9 March 2009

**Re: Site 3, Australia Avenue, Sydney Olympic Park – MAJOR PROJECT No. 06_0127
Section 75W amendments**

Levels 07 - 08

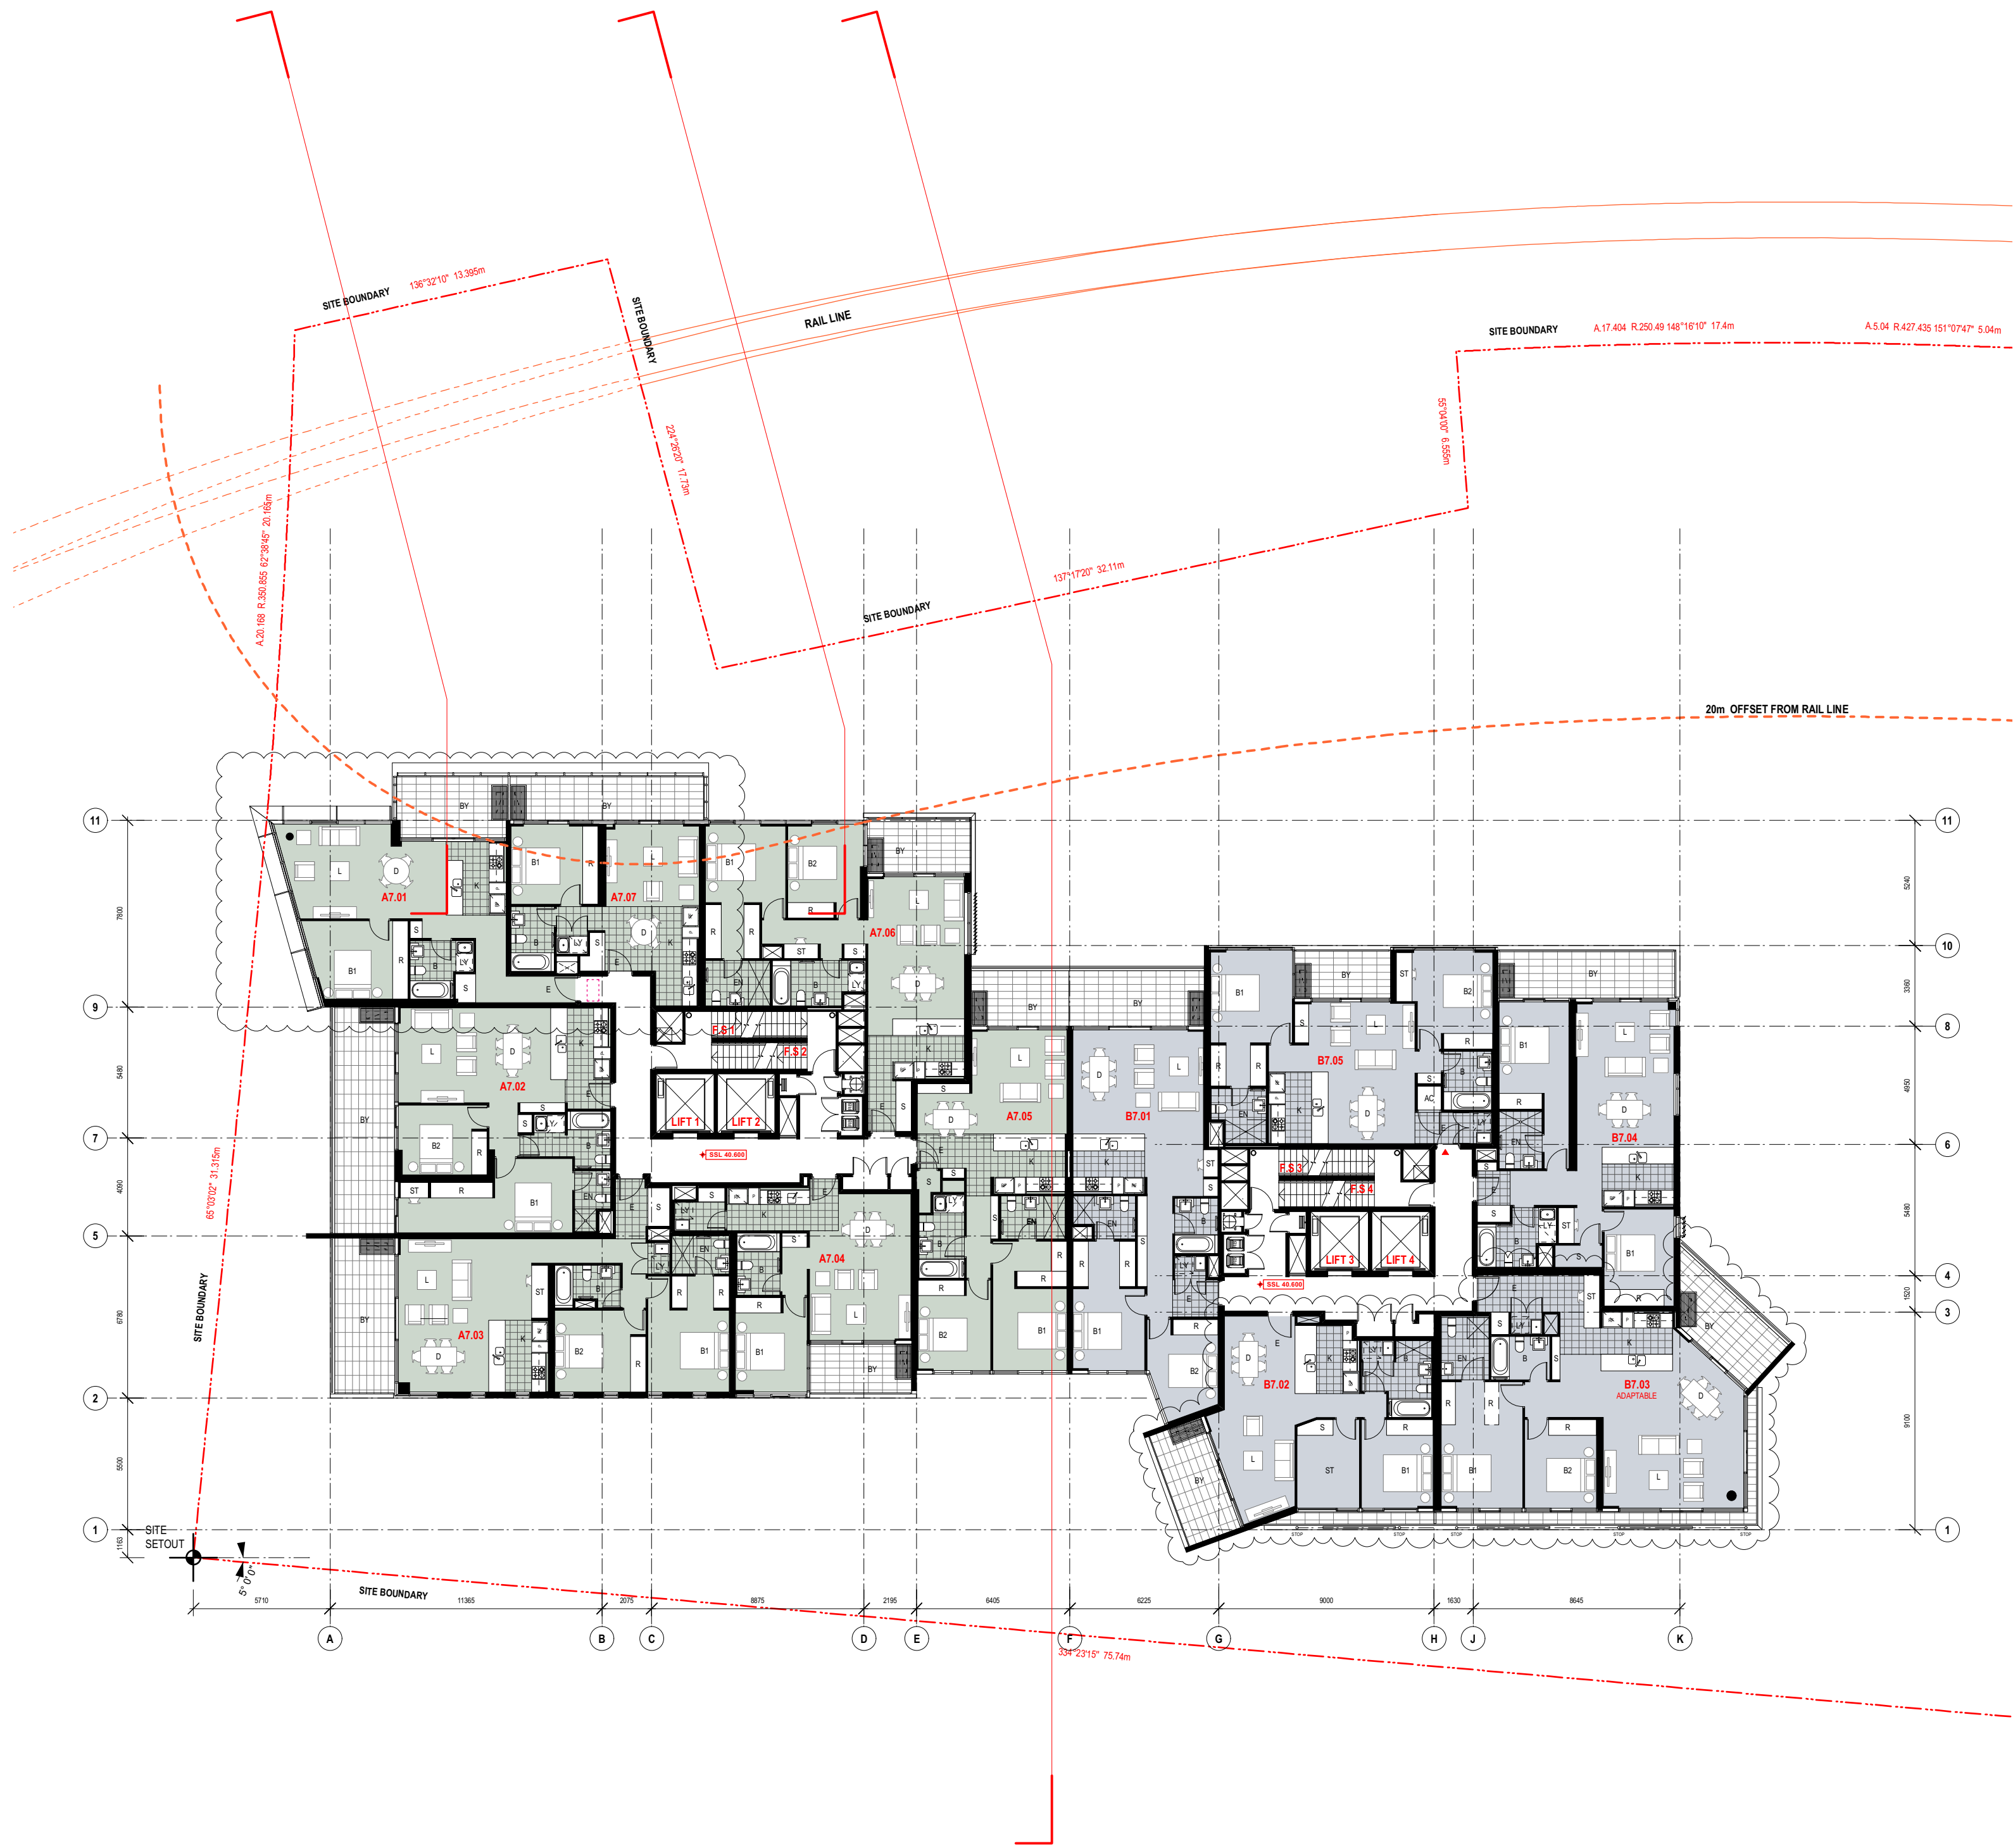
At the northeast of Tower A at Levels 7-13, 7 x 3 bedroom units have been converted to 14 x 1 bedrooms units in order to increase the number and range of affordable apartments. Overall the number of units in the development increases from 208 to 216 units (including 1 additional unit at Level 1). Please refer to Plans DA013, 015, 018.

Envelope Analysis - Elevations

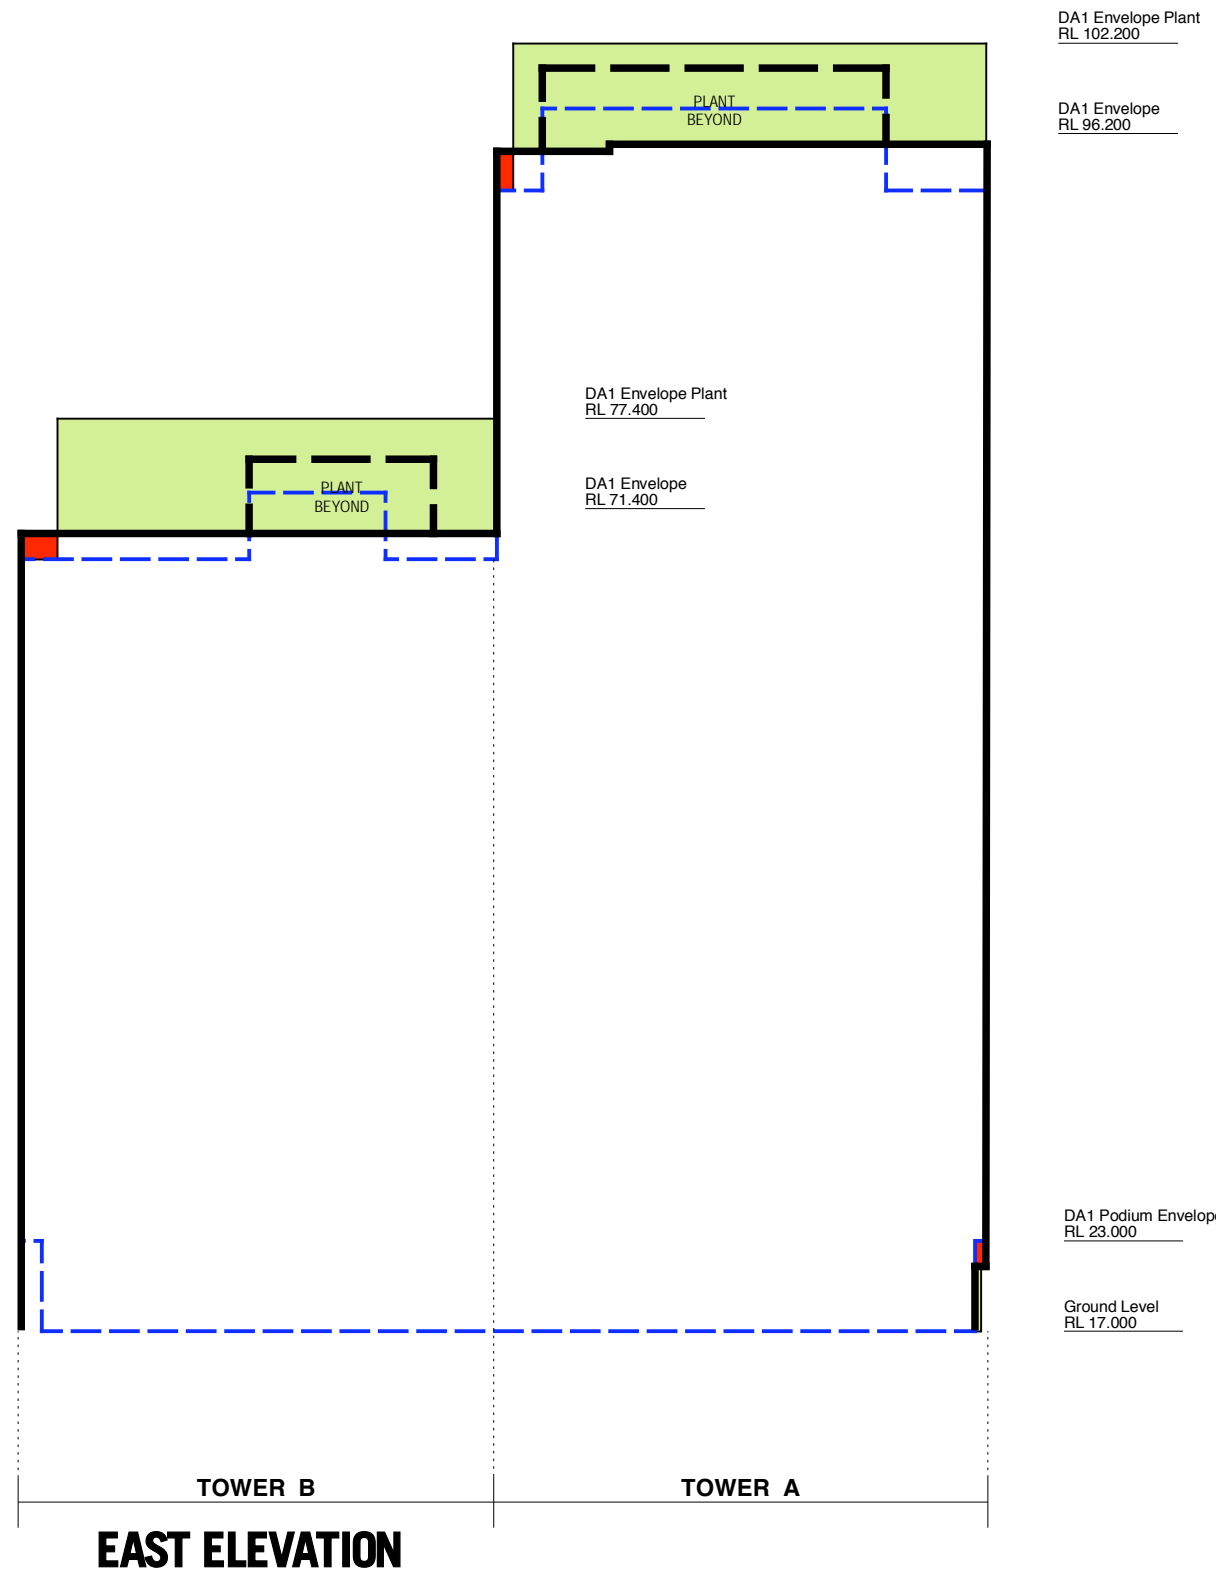
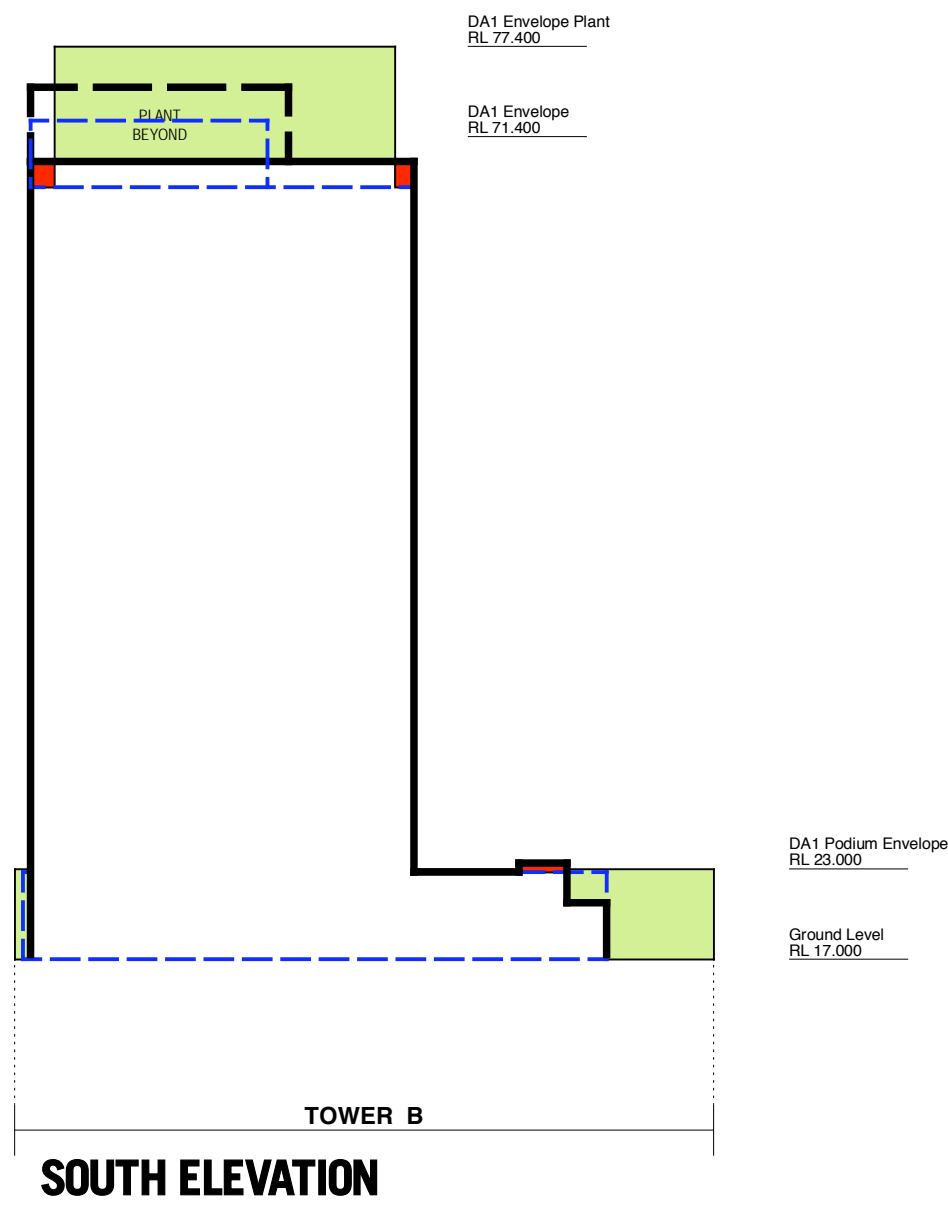
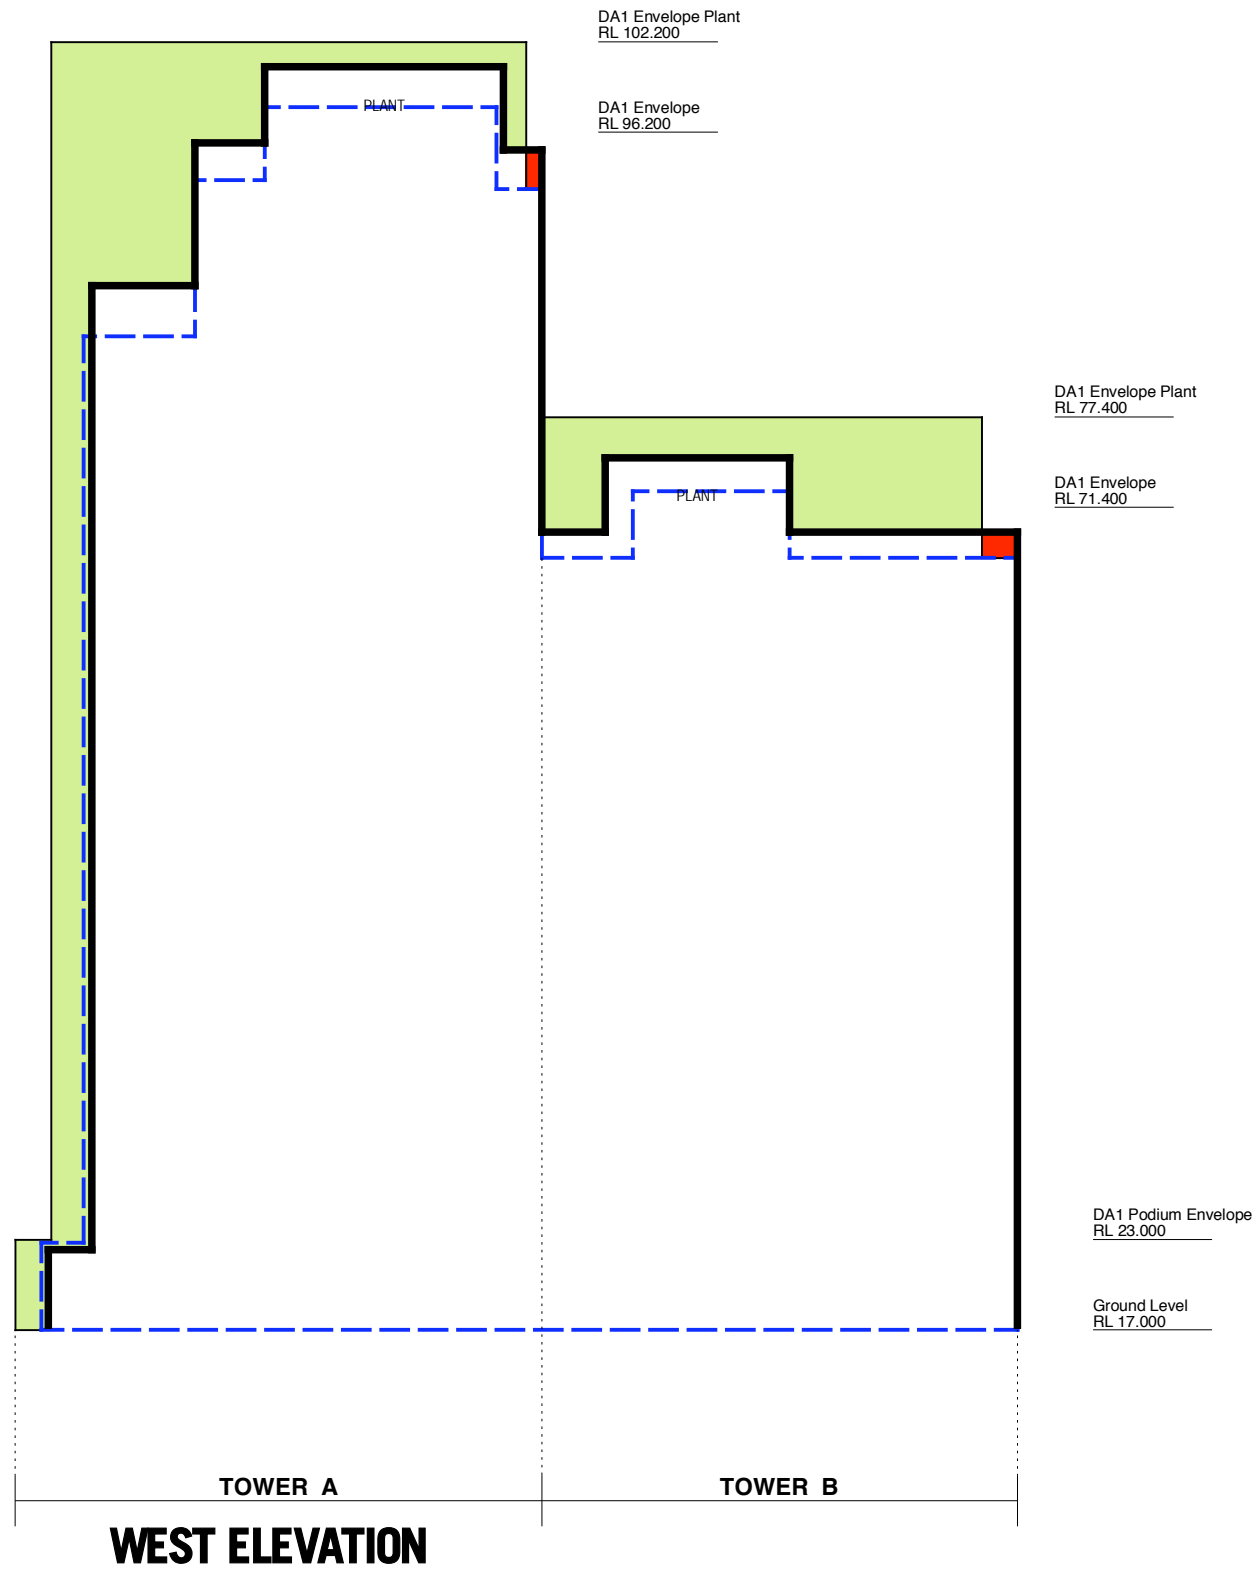
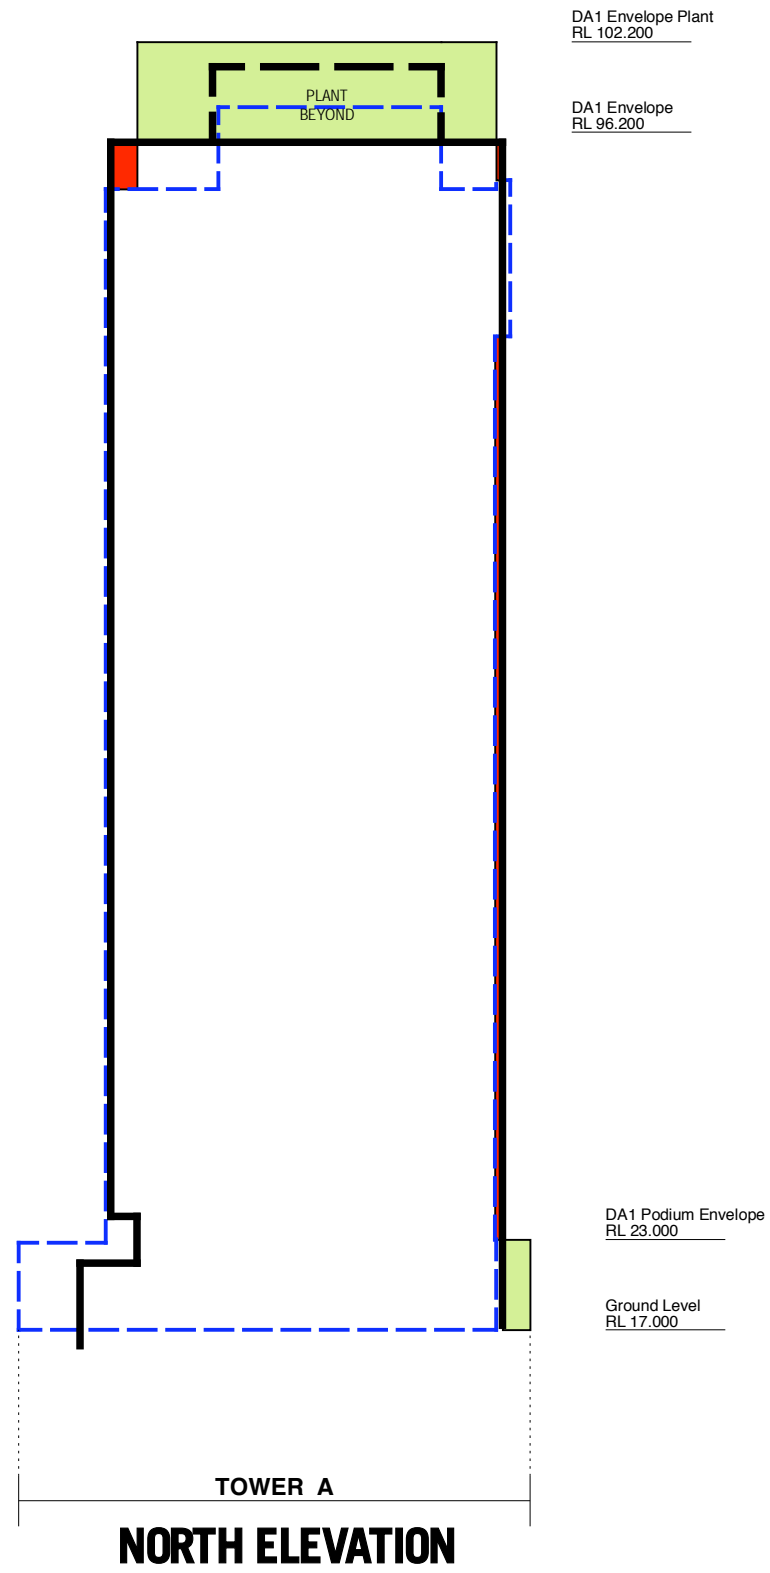
Overall this equates to Tower A part of the building being 2.6 m higher and Tower B part 1.7 m higher. In relation to the original approximate building heights of 80.65 m (A) and 55.6 m (B) the increase is minor and does not cause any significant loss of amenity to its surroundings. On 22 June the shadow of Tower A would increase by only 4.1 m at 12pm and 7.8 m longer at 9am/ 3pm. Tower B's shadow would increase by only 2.7 m at 12pm and 5.1 m at 9am/ 3pm on the same date.

The proposed increased total building heights are still lower than the approved Stage 1 Master Plan heights. The overall building envelope is also both within and outside of the Stage 1 envelopes in the same locations as previously approved, however the minimal encroachments outside the envelope are balanced by being substantially within the envelope in other locations. Please refer to Envelope Analysis DA037, Section DA051, Elevations DA100-103 and Shadow Diagrams DA151.
